# CITY OF ALBUQUERQUE

**Re: Sundowner Hotel (Parking Garage Only) BP-2018-21352**  
**110 Union Square Street**  
**Temporary Certificate of Occupancy**  
**Transportation Development Final Inspection**  
Engineer's/Architect's Stamp dated 6-12-18 (K14D017)  
Certification dated 11-13-19

Based upon the information provided in your submittal received 11-14-19, Transportation Development has no objection to a Temporary Certificate of Occupancy based. This letter serves as a "green tag" from Transportation Development for a Temporary Certificate of Occupancy to be issued by the Building and Safety Division.

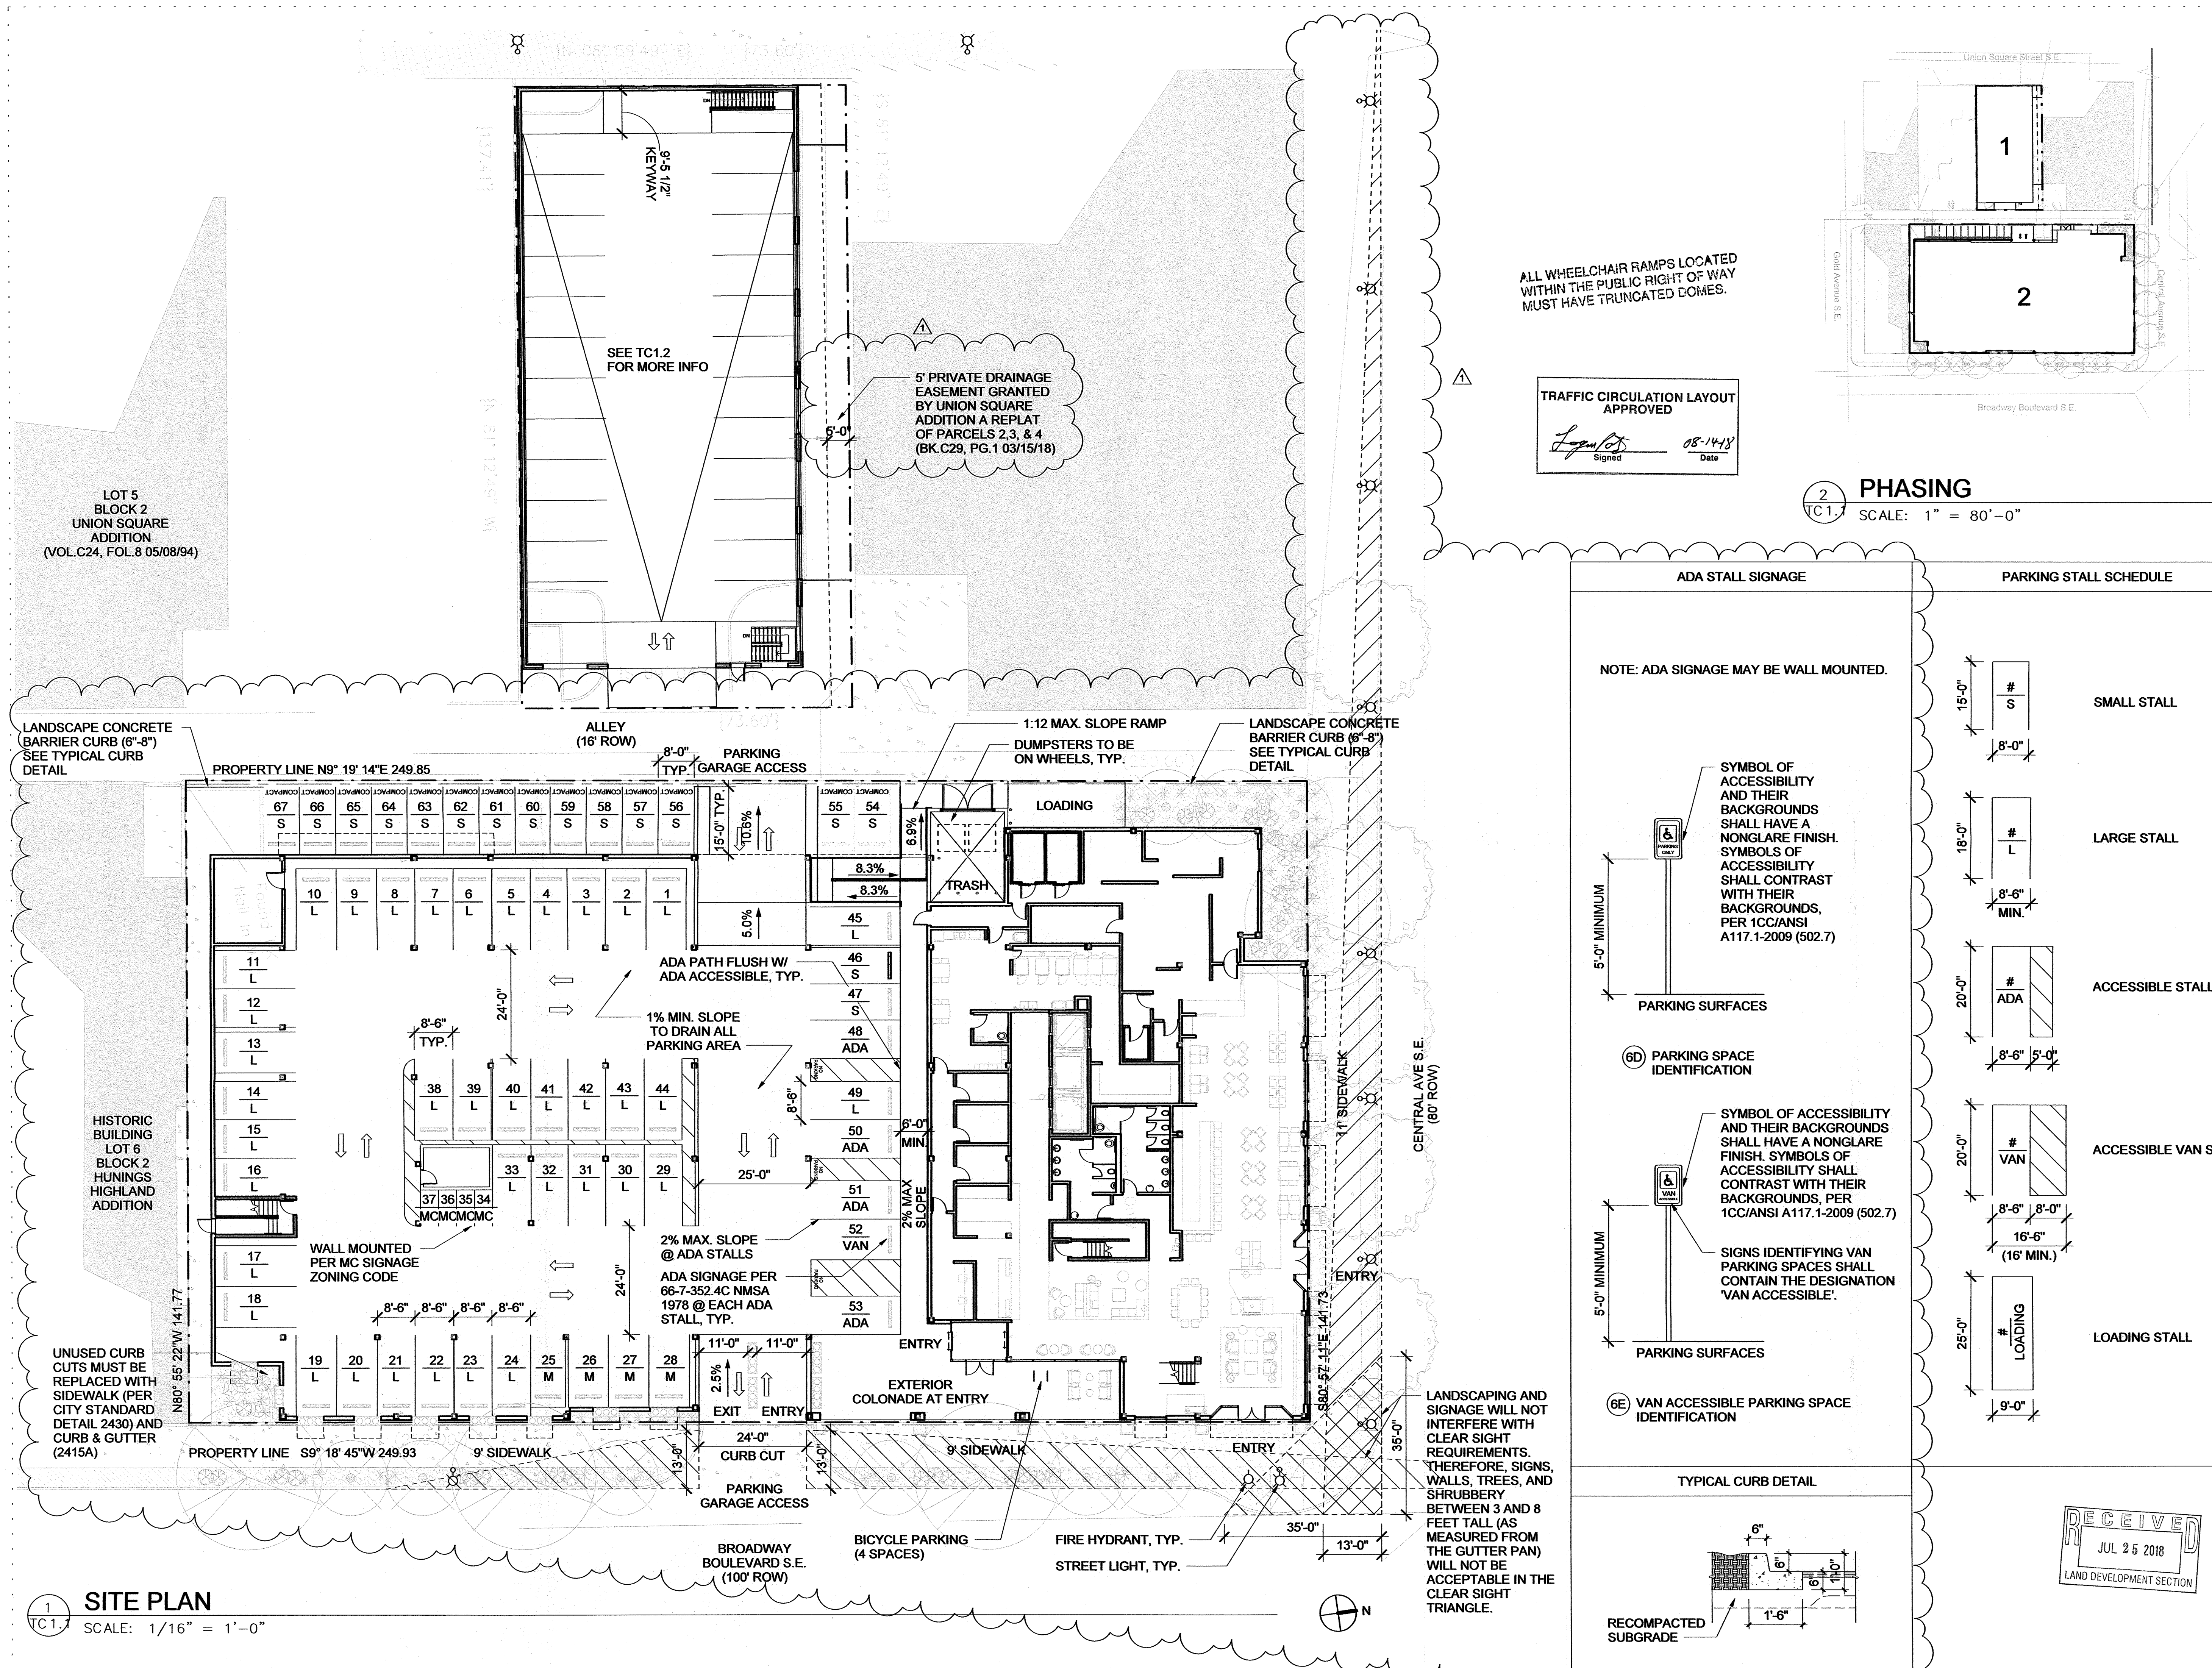
- Please remove temporary ADA parking and access aisle form alley (Once alley paving is complete please send pictures for release of final CO)
